# Comments for Planning Application 2020/1267/FUL

Application Number: 2020/1267/FUL

Address: Land To The West Of Neverstitch Road Skelmersdale Lancashire

Proposal: Demolition of existing buildings and erection of 200 dwellings, associated landscaping and infrastructure including access junctions from Neverstitch Road and Ormskirk Road, a temporary construction access onto Neverstitch Road, public open space including detention basin, an electricity substation, a foul pump station and other associated works.

Ground Floor

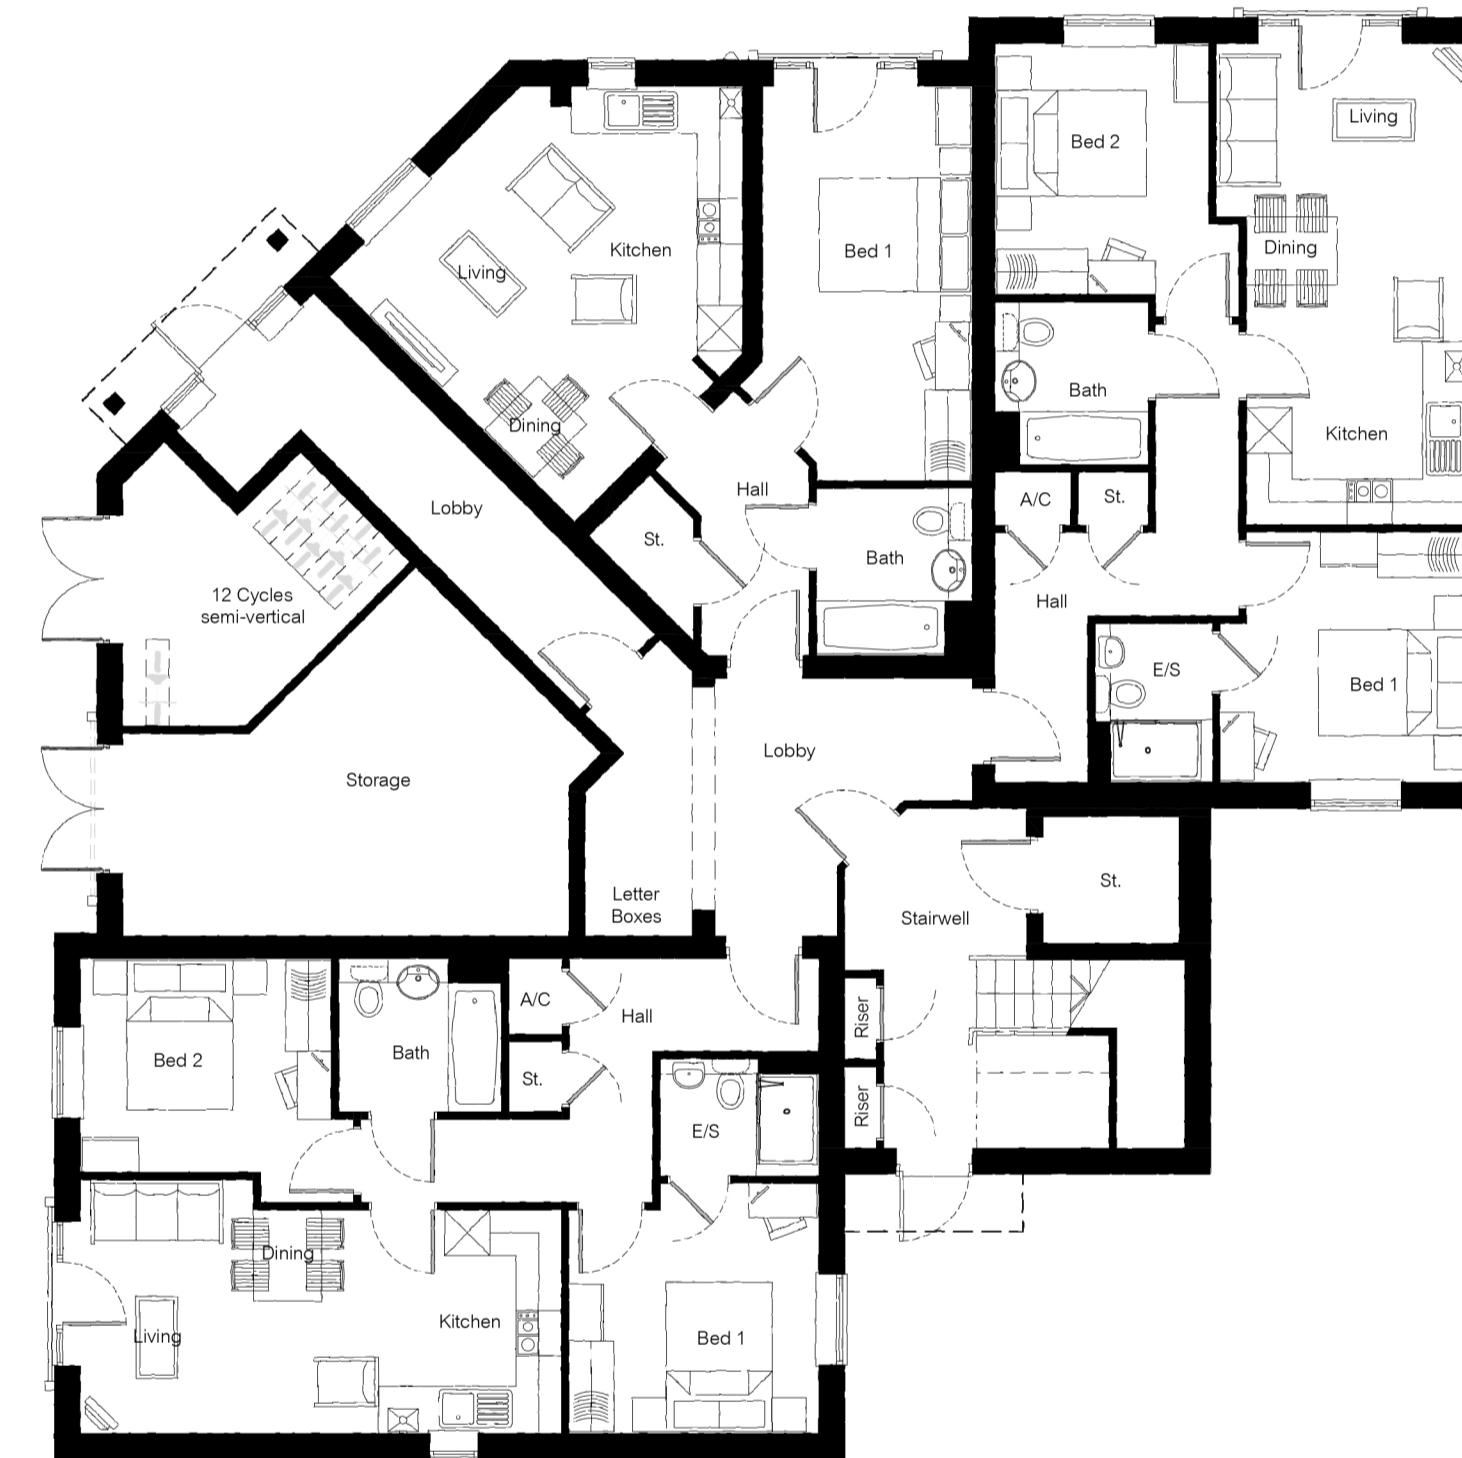
It states that "Proposals for residential development will be required to meet the following standards for car park provision and communal cycling and disabled parking provision for visitors." The standard shows that 1 bedroom properties are required to have one parking space per dwelling; 2 bedroom properties are required to have two parking spaces per dwelling. This development consists of two Copeland House apartment blocks and each block has six 2 bedroom apartments and five 1 bedroom apartments, therefore the required car parking provision for each apartment block within this development should be 17 car park spaces. There are 11 allocated. Less than two thirds that required by the West Lancs Borough Council standard. The two apartment blocks require an additional 12 parking spaces.

Within the same Policy, Policy IF2, an allocation for disabled parking should also provided, "1 space per 10 dwellings". Both blocks should also provide a disabled parking bay, two in total.
